Contact: Katrina Stankowski
Phone: (02) 9873 8569
Fax: (02) 9873 8550
Email: Katrina.Stankowski@heritage.nsw.gov.au
File No: 10/11865
Job No: A766316
Your Ref:MP11_0092

The Heritage Council has received an invitation via letter (received on the 29 February 2012) to provide a submission on the Environmental Assessment for the Sydney CityGrid Stage 2A(ii) project which is currently on exhibition. It is noted that comments have previously been provided regarding various stages of this overall project in 2009, 2010 and 2011

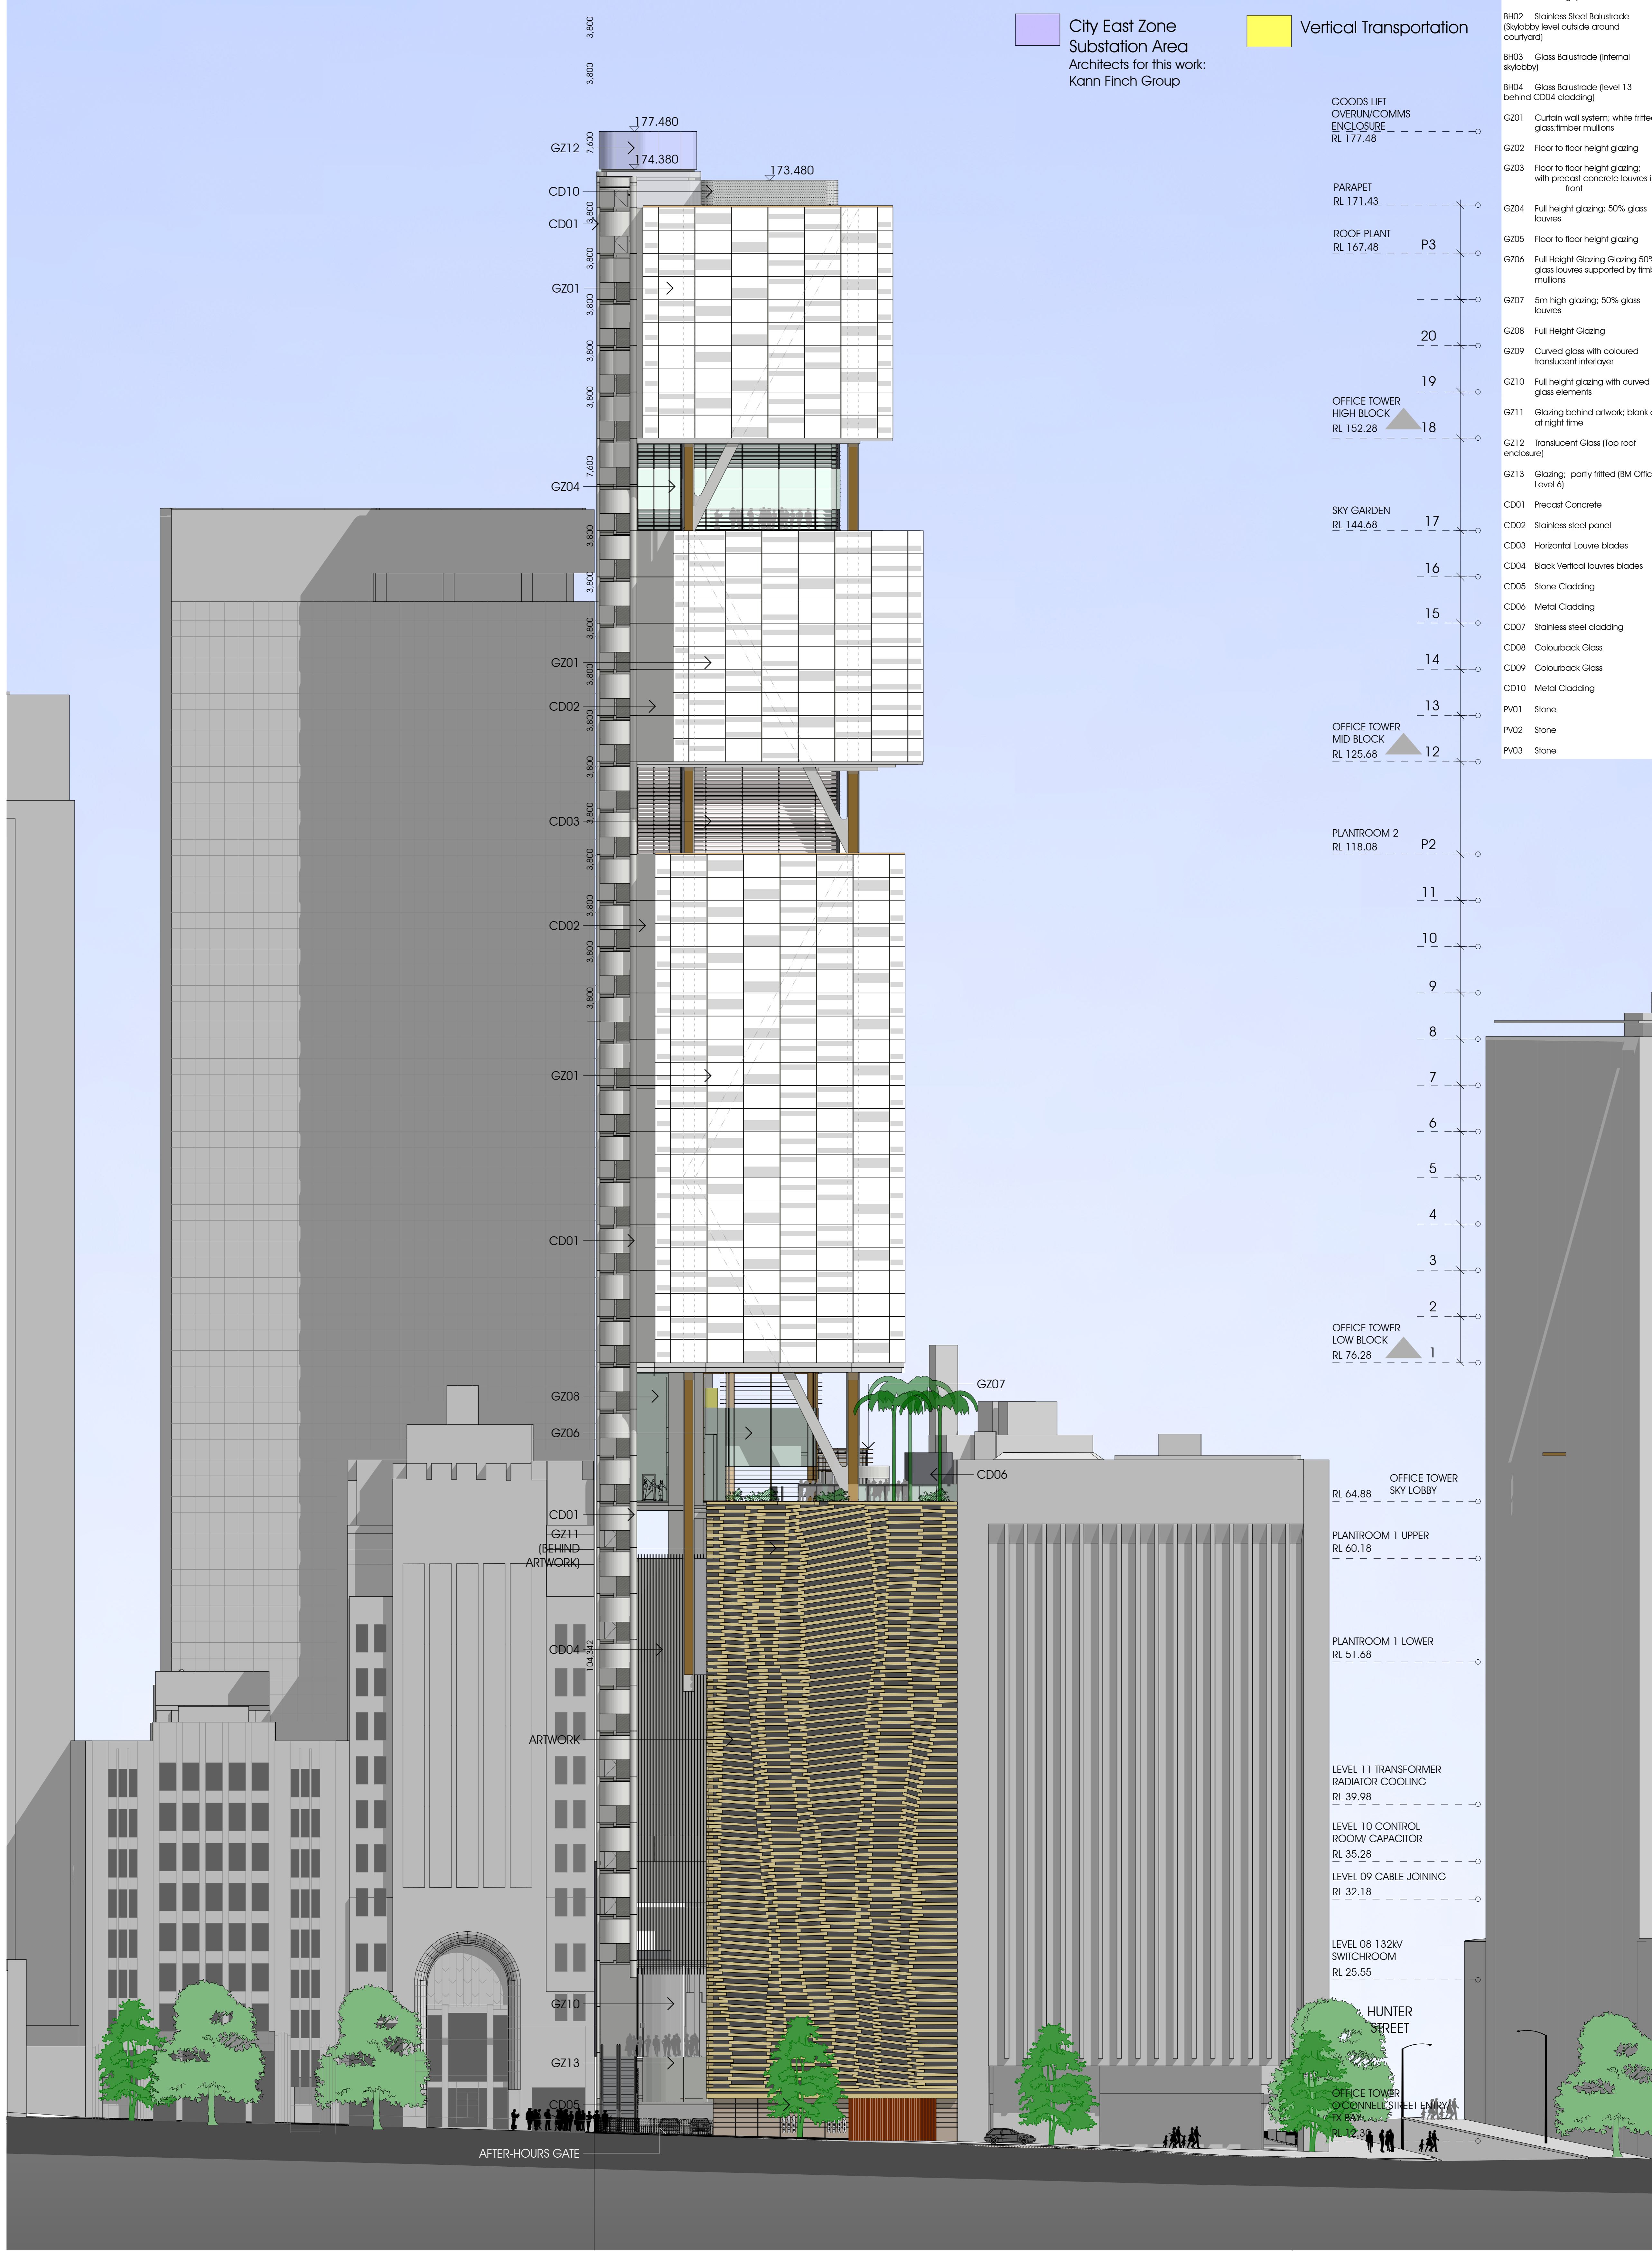
3. It is considered that aspects of the design for the building proposed at 33 Bligh Street, specifically the proposed external fire staircases, on the Bligh and O'Connell Street elevations has the potential to impact visually on the architectural character of the surrounding historic buildings.

The relationship between the proposed rounded fire stairs and the rectilinear walls of the adjoining historic buildings needs further design resolution. In this context a right

angled external staircase could be a better option in place of the currently proposed rounded stairs.

In addition, the junction between the proposed stairs and the historic buildings should be as light and transparent as possible. It is considered that the current design of the proposed fire stairs does not form an acceptable junction with a heritage building in terms of geometry and material.
